## Appeal Decision

**Appeal Ref: APP/R5510/D/23/3332764**

**185 Eastcote Road, Ruislip, Hillingdon, HA4 8BJ**

- The application sought planning permission for part-retrospective application for the erection of a single storey rear and part side extension and part garage conversion to habitable use without complying with a condition attached to planning permission Ref 22142/APP/2022/3853 dated 3 March 2023.

3 Existing Front_Elevation
1 : 100

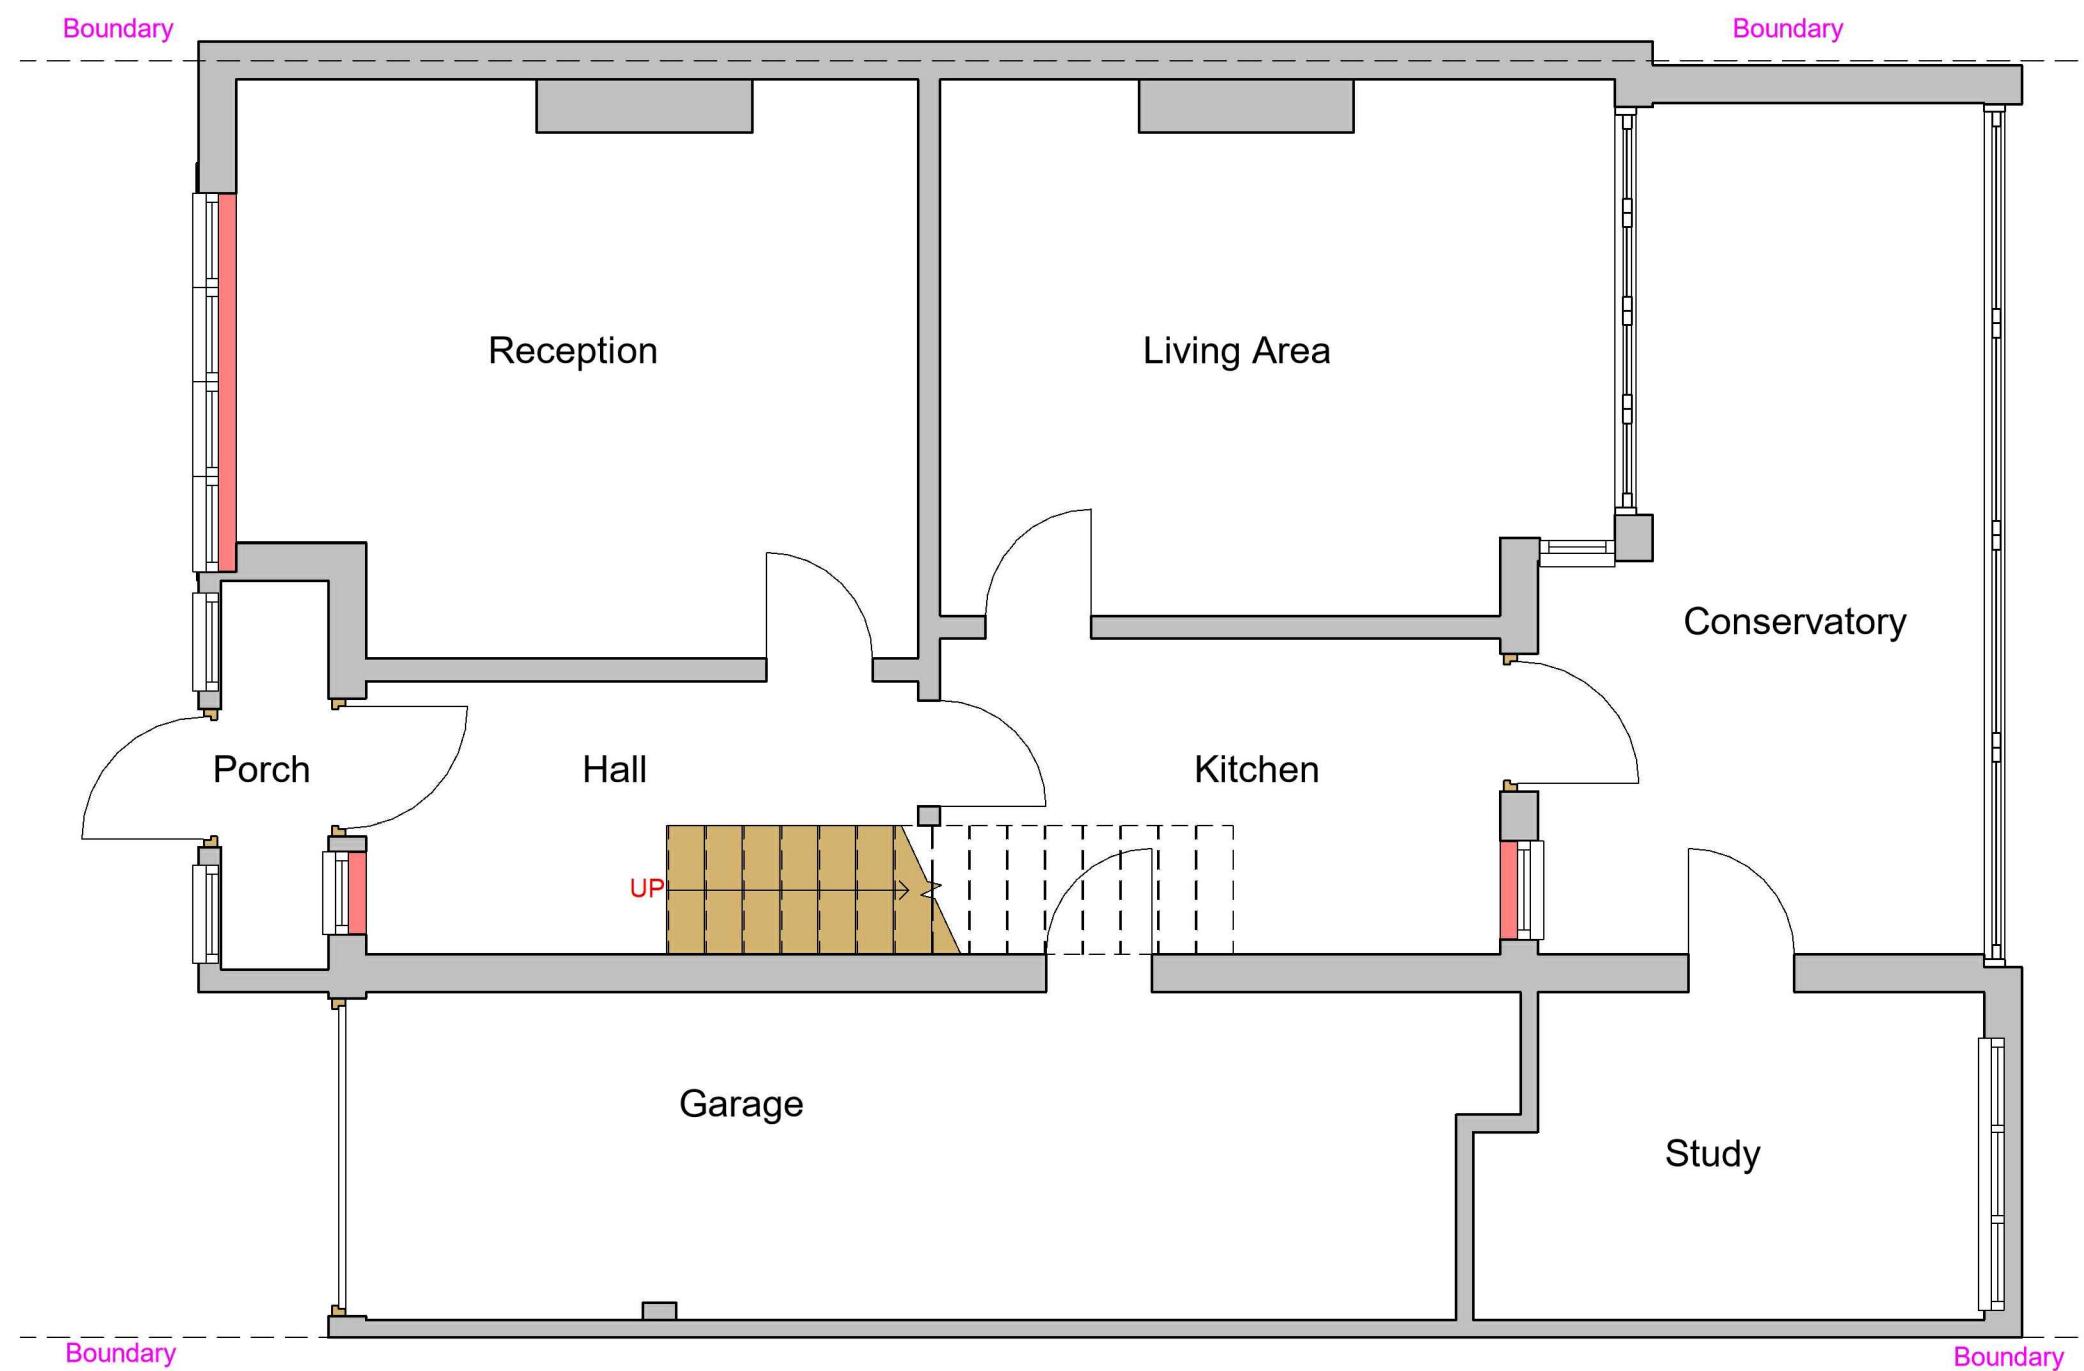
5. Before the recent extensions and alterations, the dwelling featured a combination of facing materials. These included the white render and black boarding on the principal elevation which combined to create the mock Tudor design which the Council sought to retain, a brick porch and roughcast render on the side elevation.

2 Proposed Front_Elevation
1 : 100

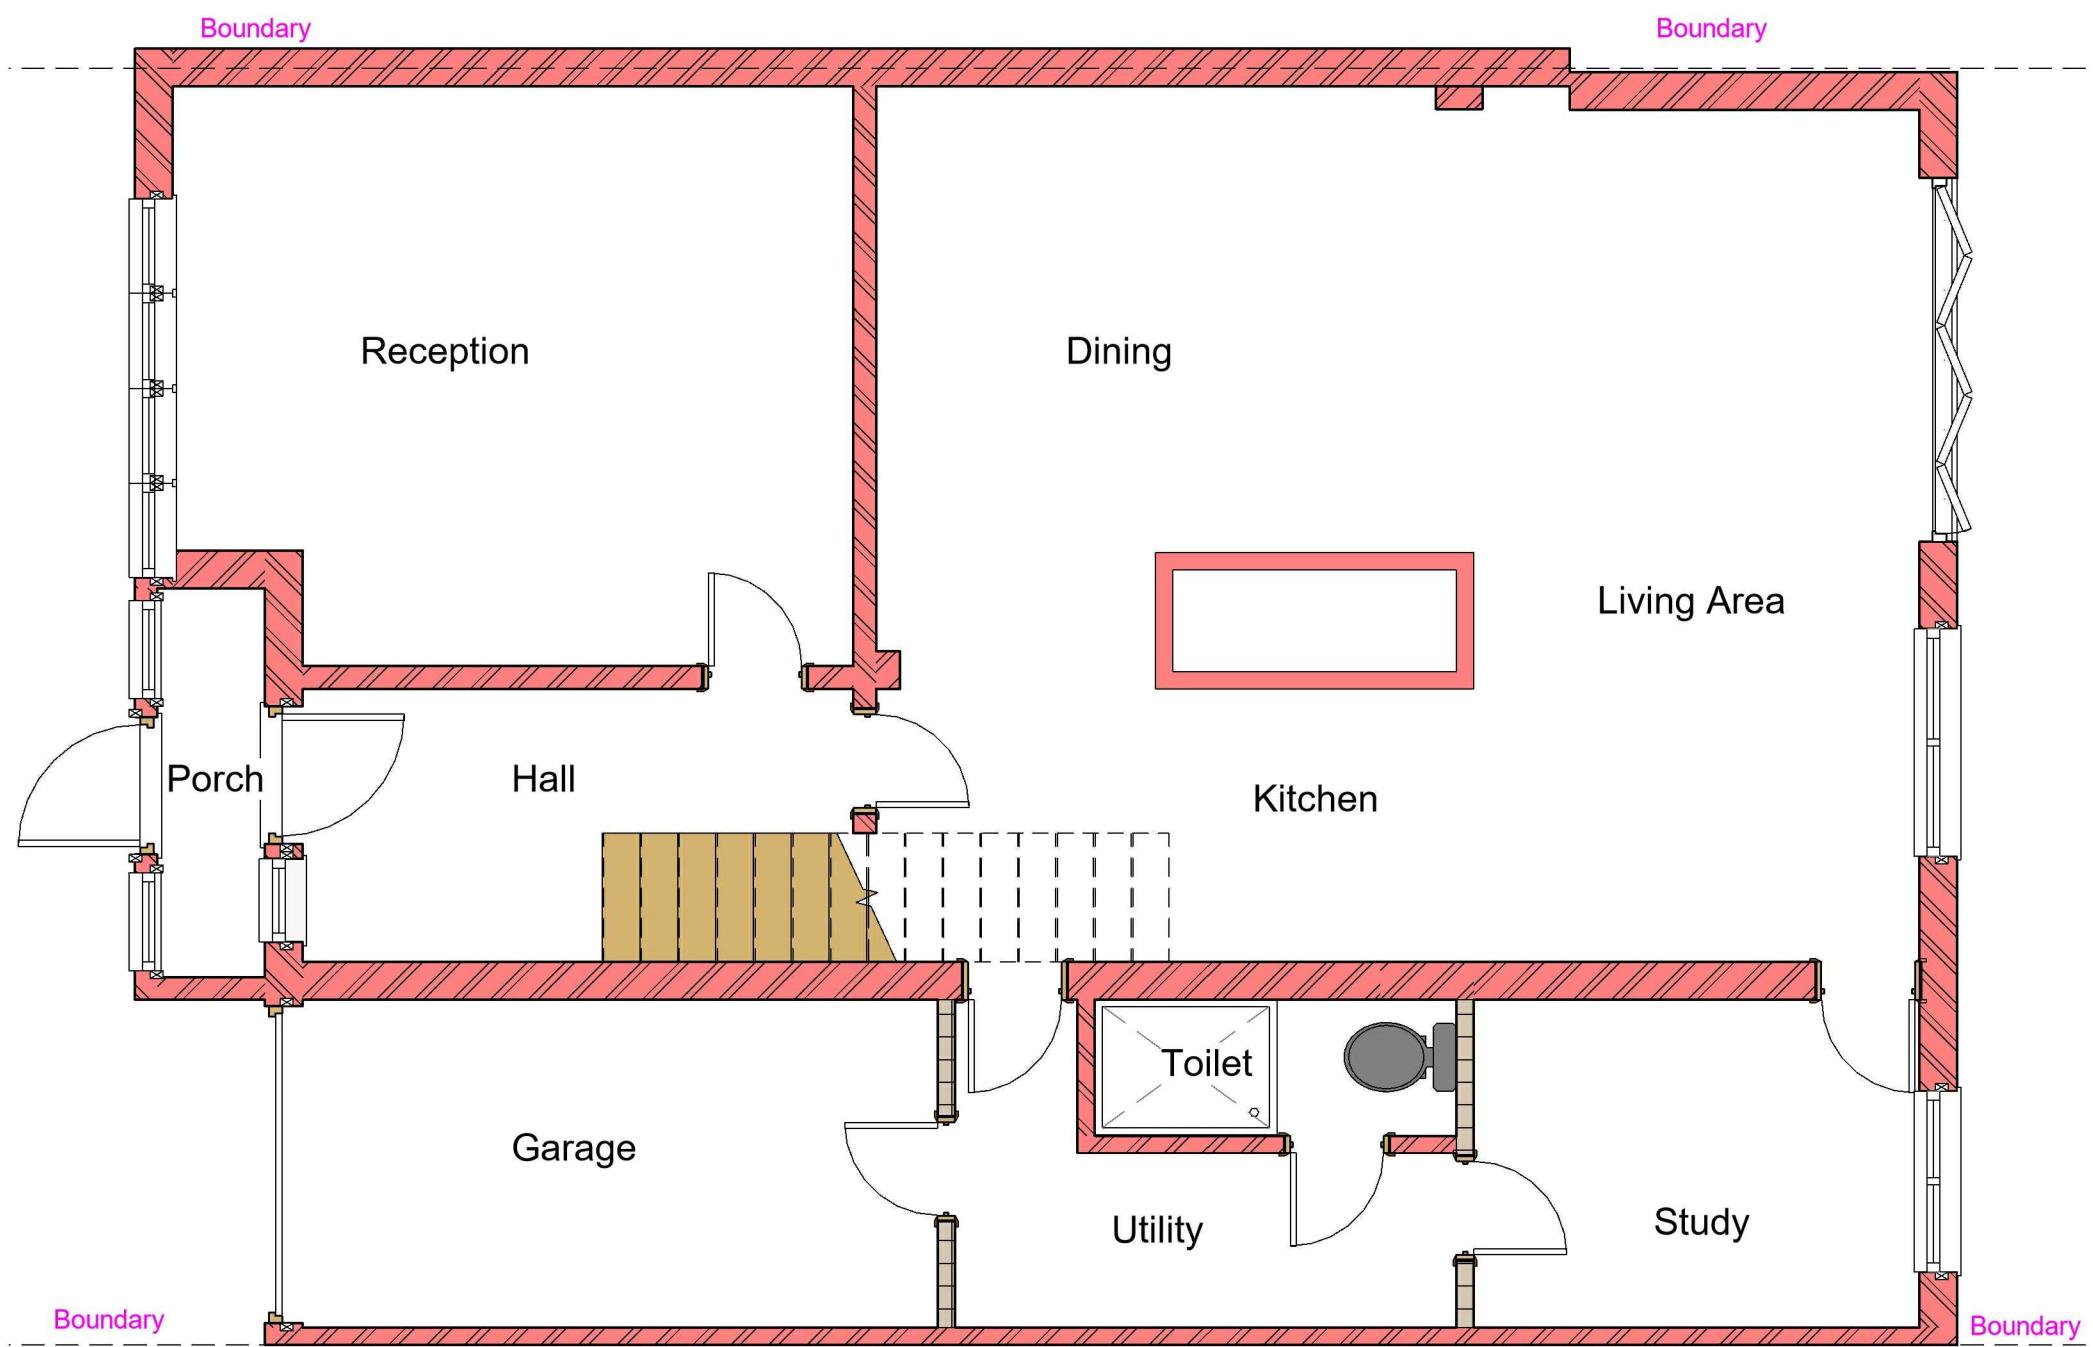
4. The main issue of the appeal is the effect of the development on the character and appearance of the area, with particular regard to the loss of the Mock Tudor detailing to the front elevation.

6. The appeal site forms part of a group of eight semi-detached dwellings on the northern side of Eastcote Road that have retained the mock Tudor detailing on their principal elevations, except the appeal site as all elevations of the dwelling have now been rendered white. While white render is a widely used facing material for dwellings in the locality, it forms part of a palette of materials used in their construction, contributing to their architectural character, rather than being the sole facing material.

7. The application of the new render at the appeal property has created a stark contrast with the established character of the group of eight dwellings that were constructed with the mock Tudor detailing on the principal elevation. The plain white render on all elevations creates a bland, generic appearance that fails to respect the design and character of the original dwelling, neighbouring dwellings and the locality in general. The result is a very conspicuous unbalancing of the pair of semi-detached dwellings, which is harmful to the character and appearance of the street scene.

8. Drawing these points together, the development has failed to incorporate the principles of good design as facing materials have been applied inappropriately to create a harmfully asymmetric appearance, contrary to the character and appearance of the area. The proposal therefore conflicts with Policy BE1 of the Hillingdon Local Plan: Part One Strategic Policies 2012 ('HLP Part One') and Policies DMDH 1 and DMHB 11 of the Hillingdon Local Plan Part Two – Development Management Policies 2020 ('HLP Part Two'). Among other things, these policies state that new extensions and alterations should respect the design of the original house and be of matching materials, which the appeal proposal fails to achieve.

Broken wall

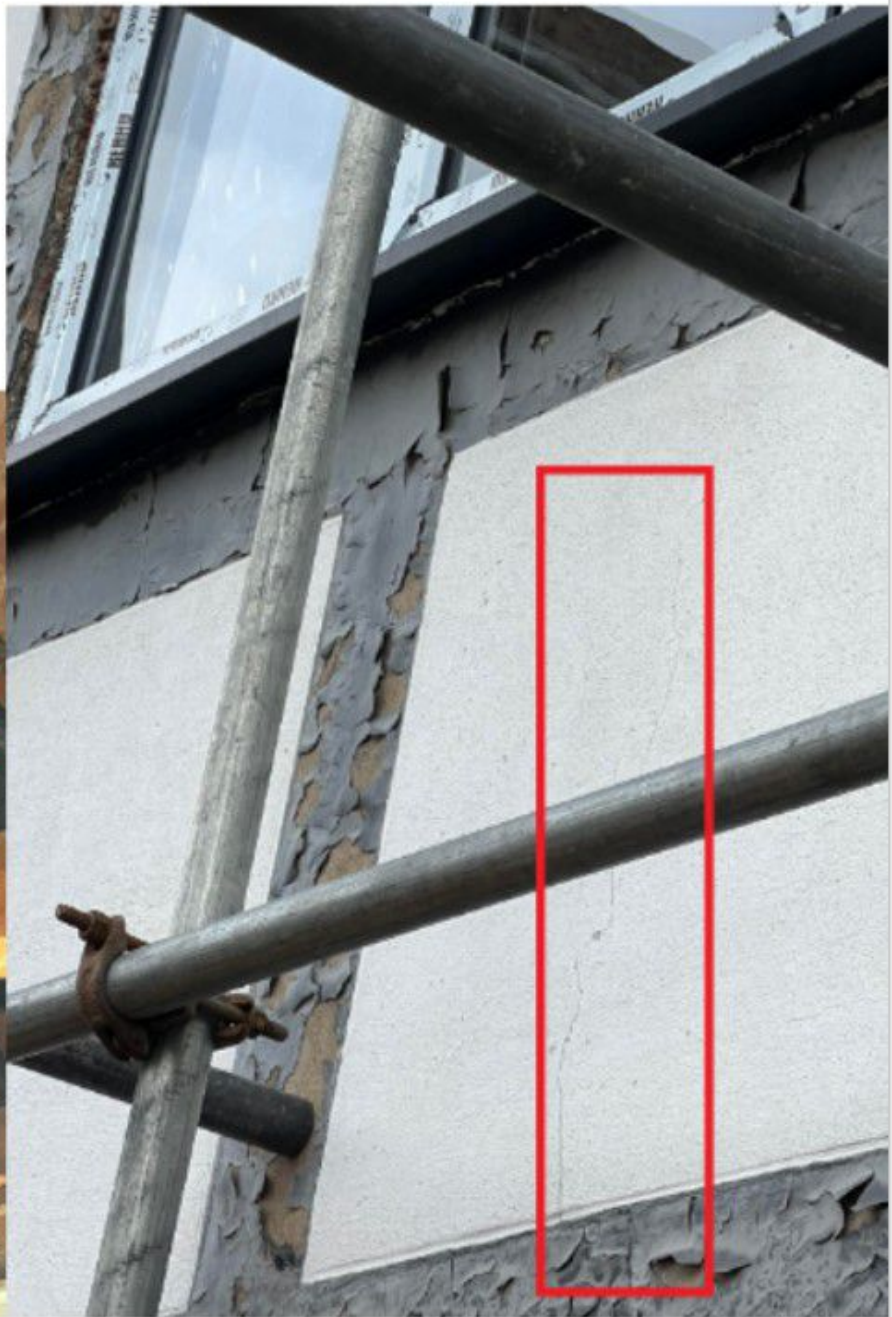
9. The appellant stated that the appeal proposal is justified to remedy damp and structural issues. However, there is no evidence before me to suggest that these issues could not be addressed whilst also retaining the mock Tudor design originally found on the principal elevation of the dwelling.
10. The appellant has referred to another appeal in the London Borough of Hillingdon which involved applying white render to a dwelling. The details provided by the appellant show it is not directly comparable to this appeal because it involves a detached dwelling in a different site context.
11. Policy HE1 of the HLP Part One is cited in the Council's reason for refusal. This is a heritage policy that is not determinative in my decision because the Council
